**20.2 MAJOR PROJECT MP09\_0066 MODIFICATION 3 – ALBERT AVENUE/THOMAS STREET, CHATSWOOD (CAR PARK SITE) SUBMISSION TO THE DEPARTMENT OF PLANNING**

**SUBMISSION BY WILLOUGHBY CITY COUNCIL ON PROPOSED MODIFICATION 3 OF THE APPROVAL MP09\_0066 FOR THE SITE KNOWN AS THE THOMAS STREET CAR PARK SITE IN CHATSWOOD**

MEZZANINE
UPPER BASEMENT 1
A-0110 C
SECTION 75 W SUBMISSION

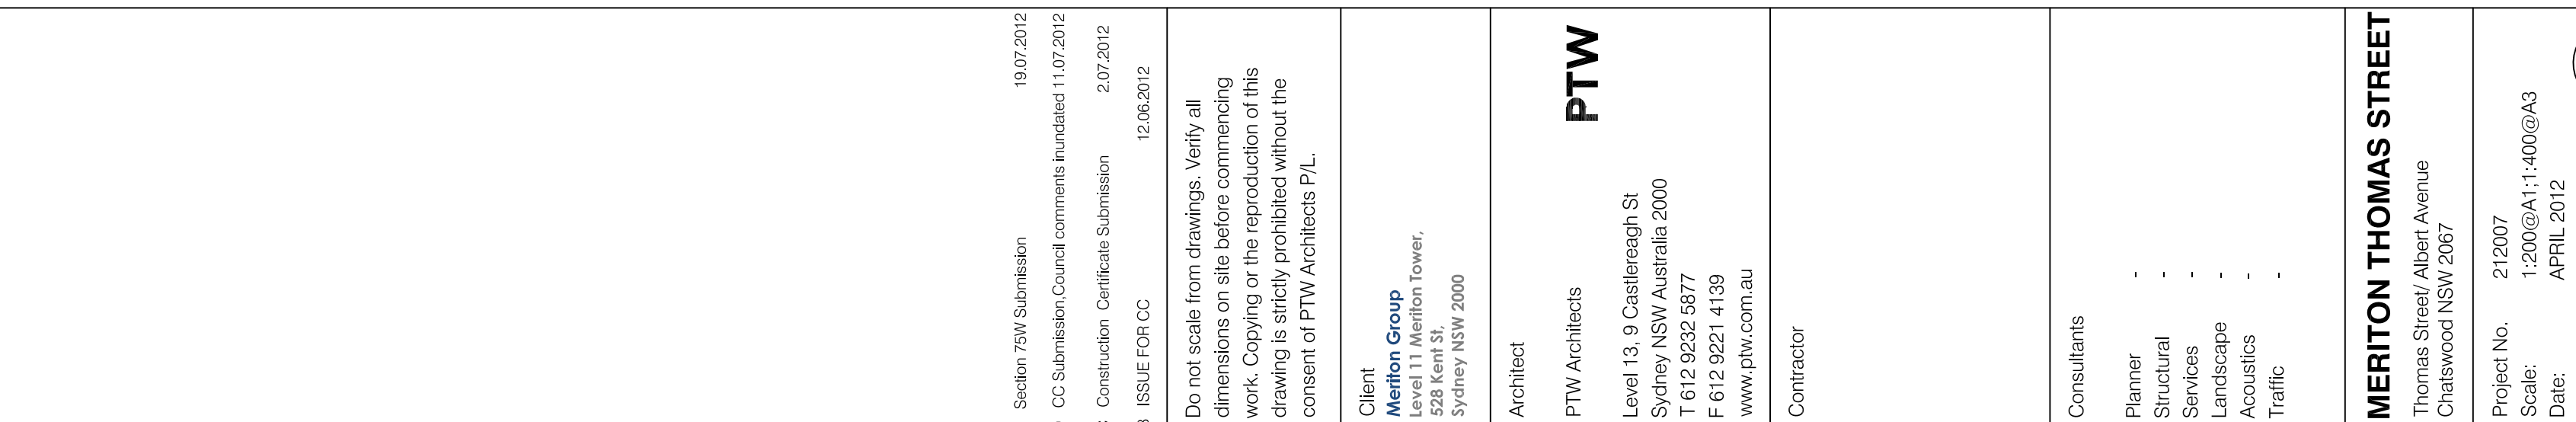
- k) The change to the layout of the Basement 1 and introduction of a mezzanine floor has resulted in the stormwater management including rainwater retention and detention being unable to be accommodated to the required capacity in the basement structure. The proponent in the additional information dated 16 November 2012 acknowledged the issue and has undertaken that the design will be amended.

1 BASEMENT 5 PLAN
1:200

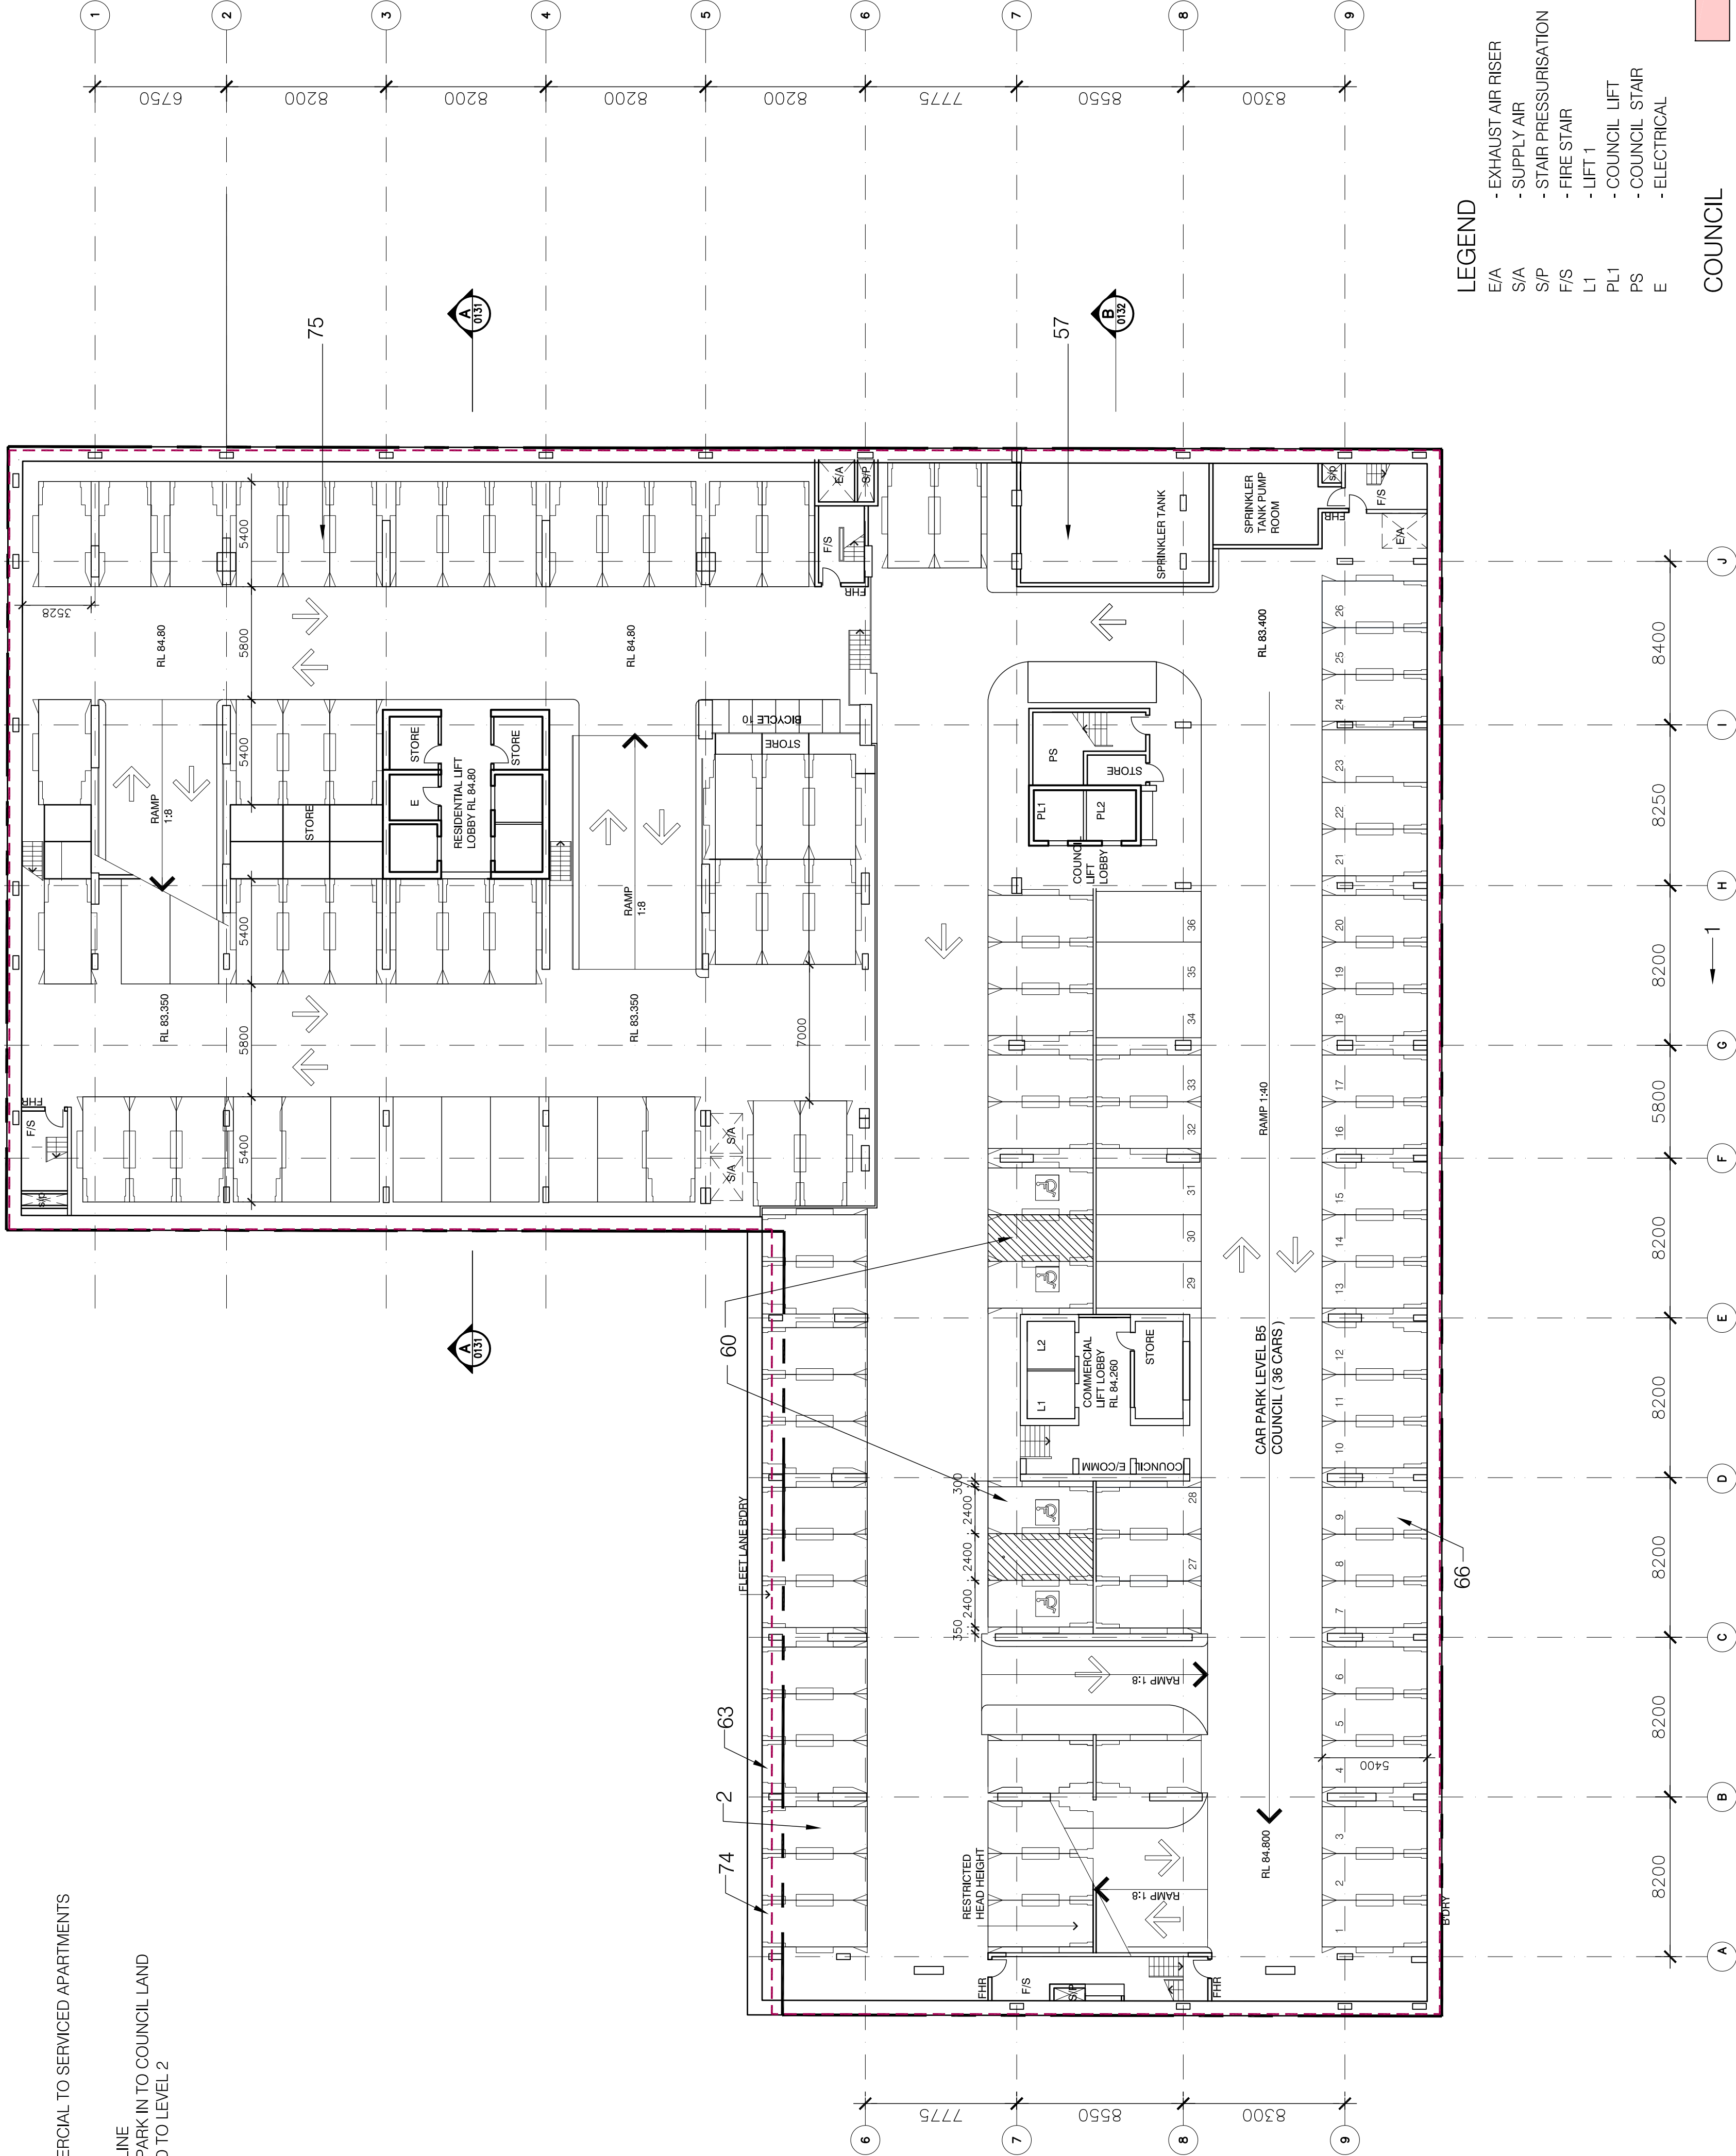
- c) The additional information dated 16 November 2012 provided an amended plan for Basement 5 that addresses previous concerns that the car park layout was inconsistent with the car parking allocation requested in the modification, that is, 166 residential spaces including 15 visitor spaces and 78 serviced apartment and retail spaces and 10 child care spaces. Also the amended plan through deletion of a circulating ramp enables the provision of an additional 2 residential spaces and 2 serviced apartment spaces giving a total of 168 residential spaces (including 15 visitor spaces) and 81 retail/serviced apartment spaces with an overall total of 508 spaces in addition to the public car parking and child care parking.
